Our ref: DOC20/933377
Your ref: SSD 8660

State Significant Development SSD 6880 – Construct and operate resource recovery facility – 90 Gindurra Road, Somersby

In addition to comments the EPA provided to you on 6 November 2020, the EPA makes the following additional comments on the Water Quality Impact Assessment (**WQIA**).

Client		KARIONG SAND AND SOIL SUPPLIES			
Project		SAND, SOIL & BUILDING MATERIALS RECYCLING FACILITY.		Status	
90 GINDURRA ROAD		SOMERSBY		PRELIMINARY	
Title		CONCEPT STORMWATER MANAGEMENT PLAN		NOT TO BE USED FOR CONSTRUCTION PURPOSES	
Drawing Number		80518002-CI-115		Revision	
				6

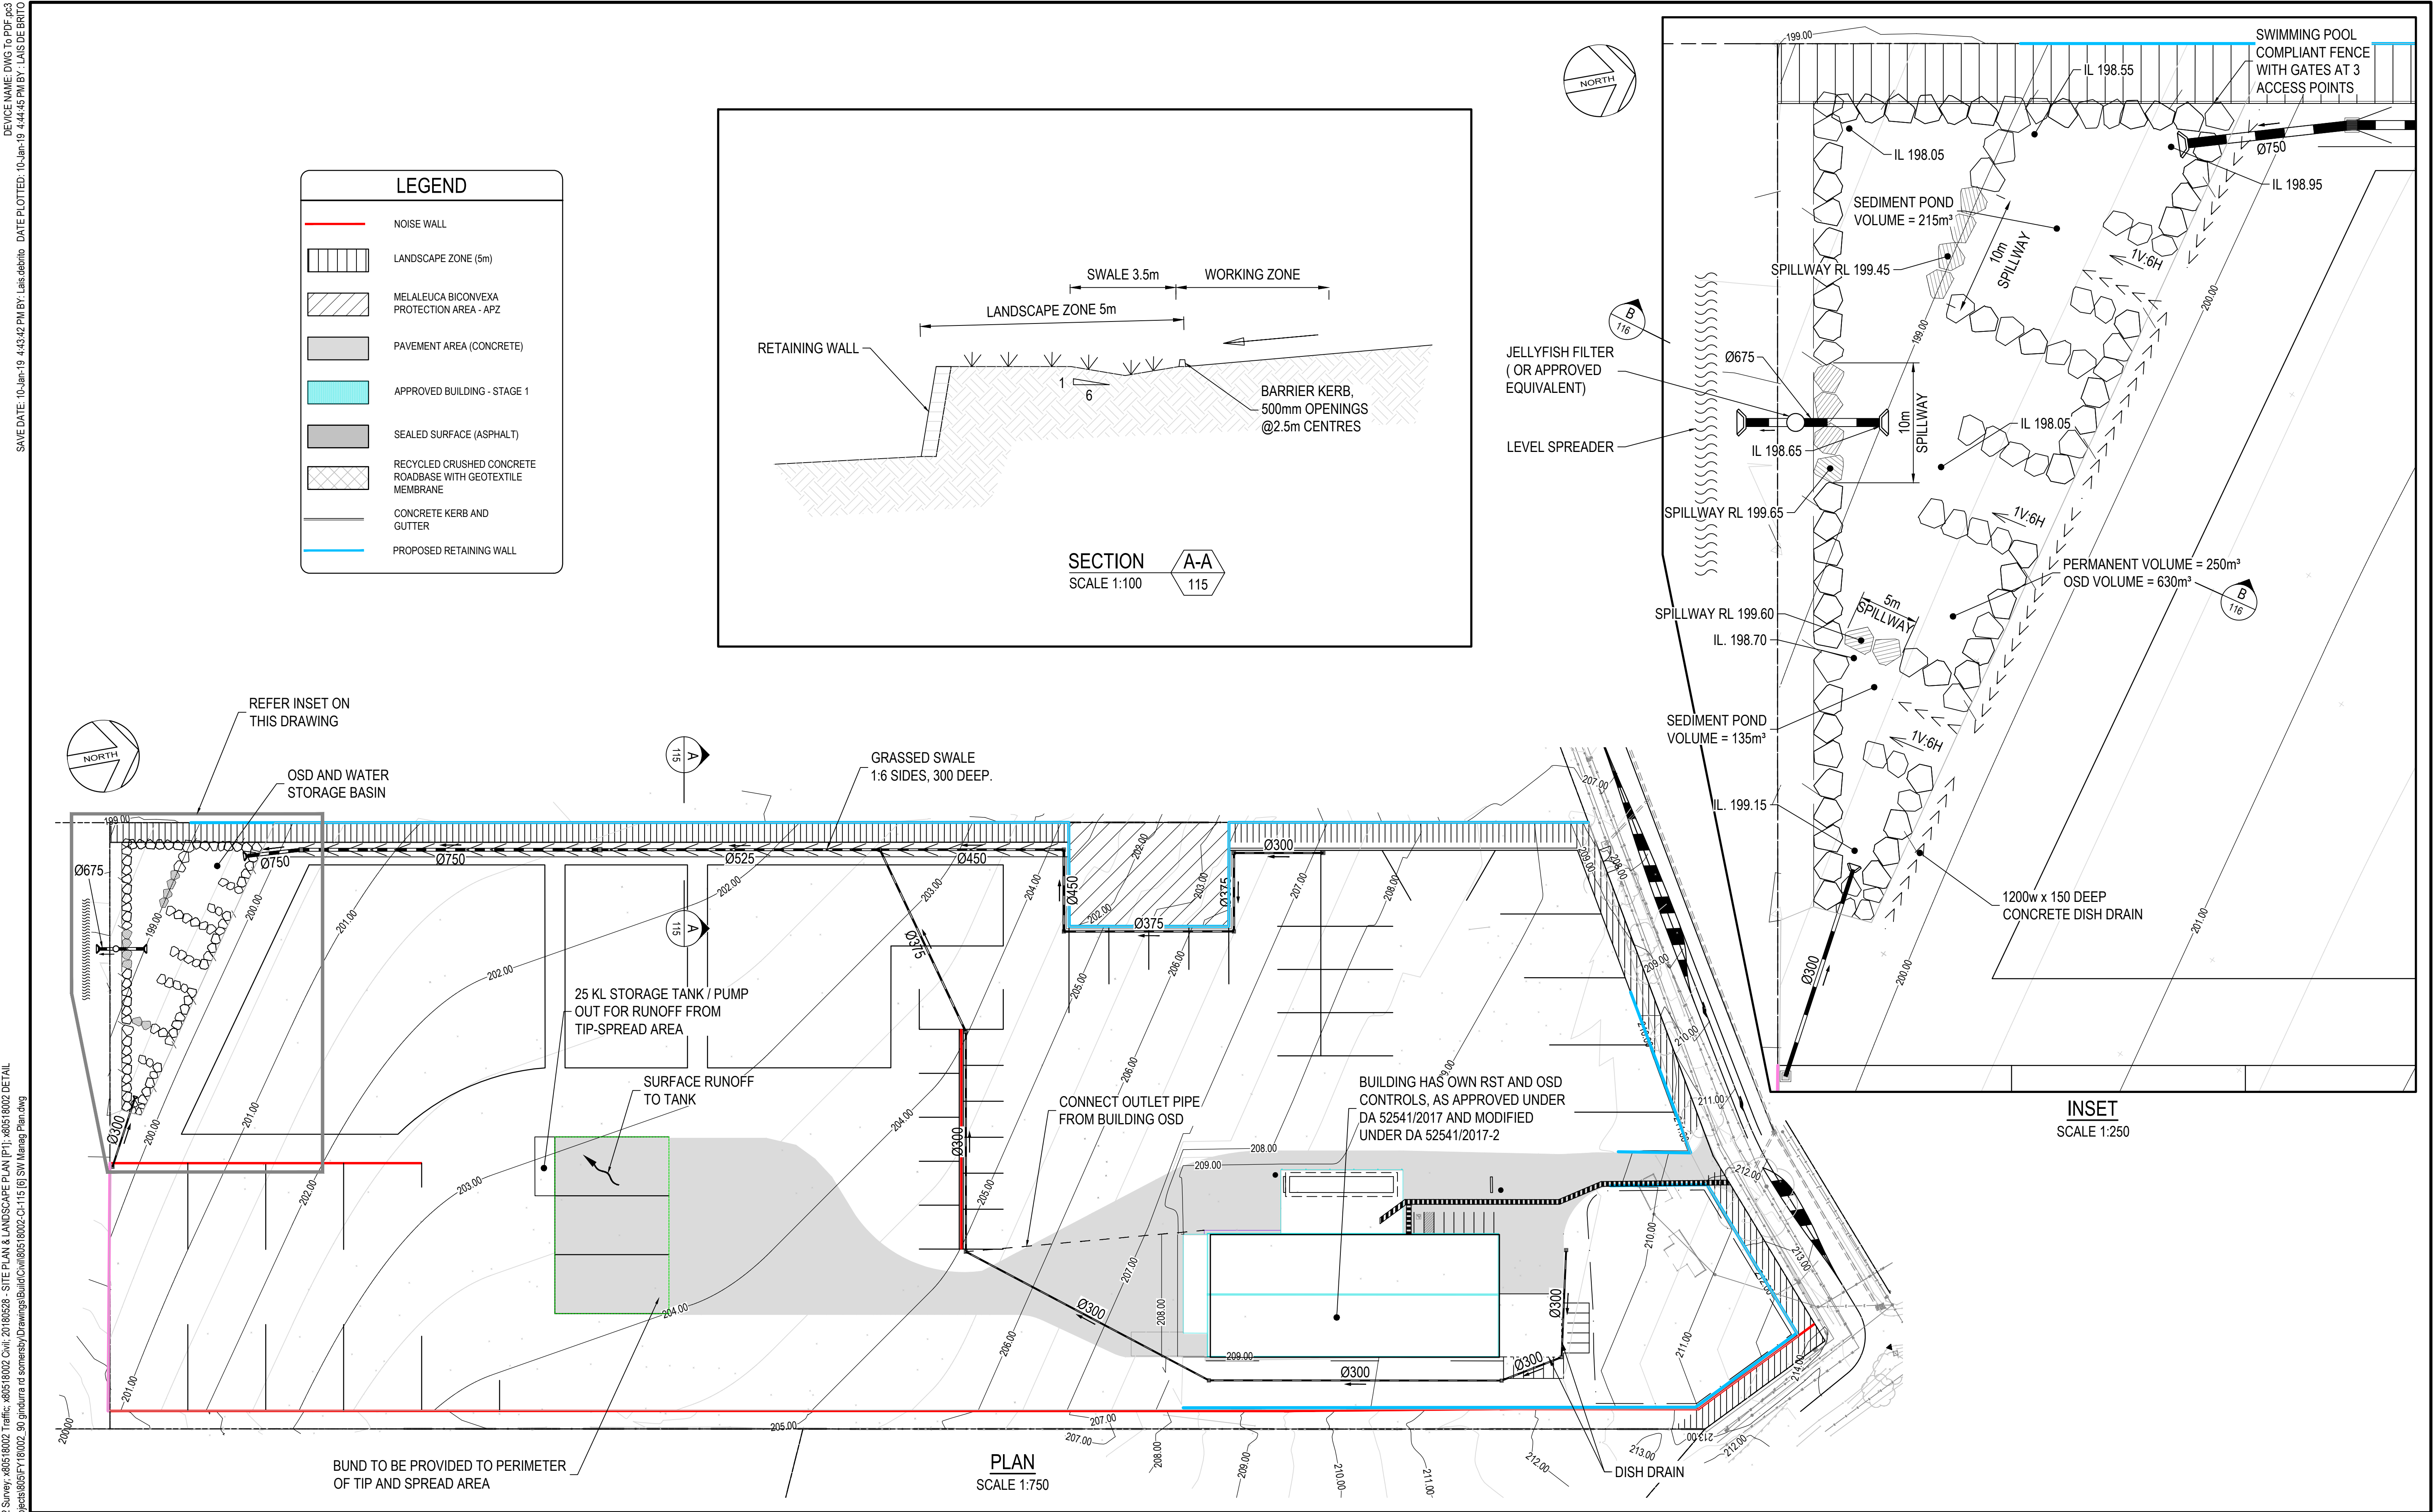
The WQIA refers to the construction and use of Floating Treatment Wetlands to treat or improve water quality prior to discharge. The EPA is concerned about the lack of evidence about the ability of the Floating Treatment Wetland to carry out its intended function. This is highlighted in the following statements taken from the WQIA:

Therefore, the EPA requires additional information (i.e. proof of concept) from the applicant in respect of the proposed Floating Treatment Wetland and its ability to prevent, control, abate or mitigate pollution caused by the construction and operation of the proposed waste facility.
